Your ref: 3/2022/0871

Date: 6th October 2022

Application 3/2022/0871: Discharge of Condition 56 (Detailed plans outlining the management and maintenance regimes and responsibilities to be adopted for the Mill Pond (from planning permission 3/2014/0183 granted on appeal APP/T2350/W/15/3119224) Land at Malt Kiln Brow, Chipping PR3 2GP

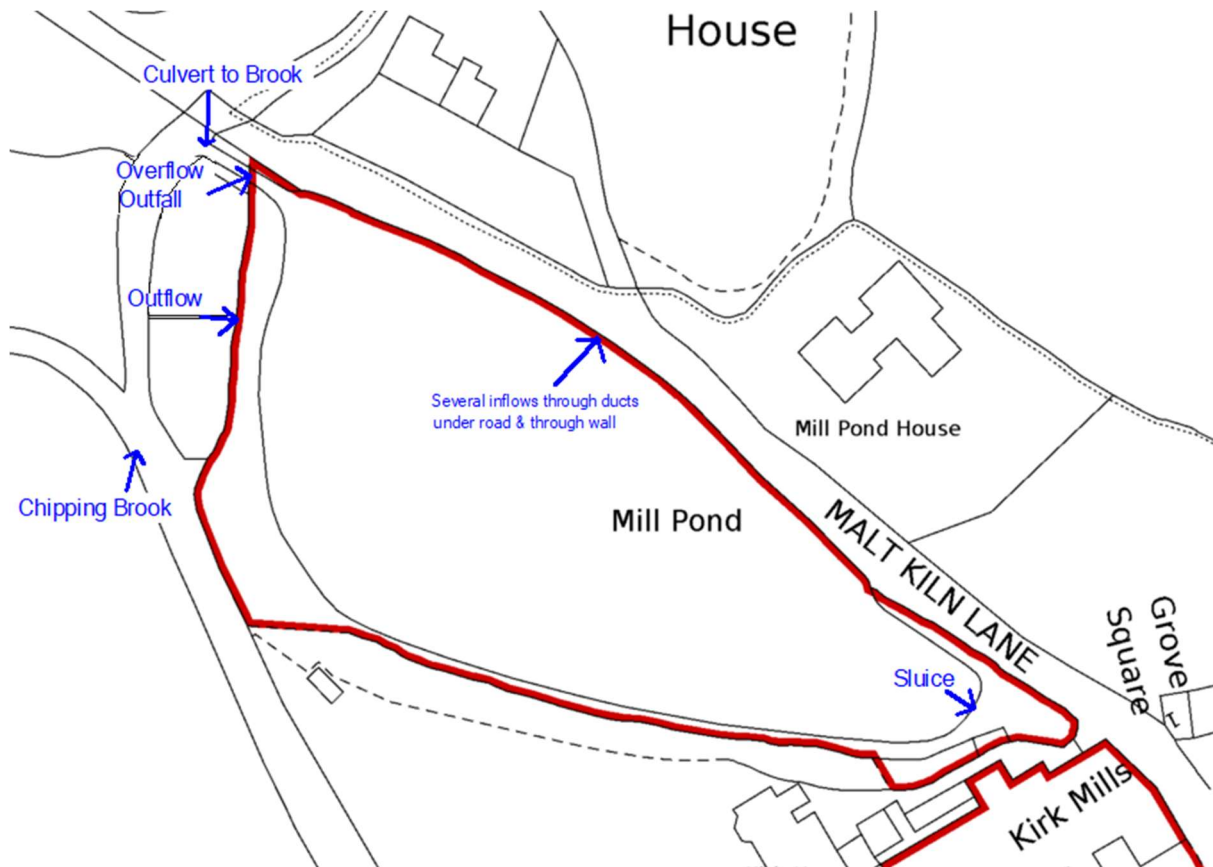
The 'Management Plan' document also states that "*The inlet and outlet for the pond has been rebuilt, providing a mechanism ...*" (p.9). No details of these rebuilt structures appear to have been provided, nor do they appear to have been covered by the works permitted in application 3/2016/0131. Is information on these works available anywhere? Are the locations and details of these structures available (a location plan and photographs MAY be sufficient, but you may wish to ask for drawings in addition) to judge if the proposals set out in the table on page 11 of the 'Management Plan' are appropriate and adequate?
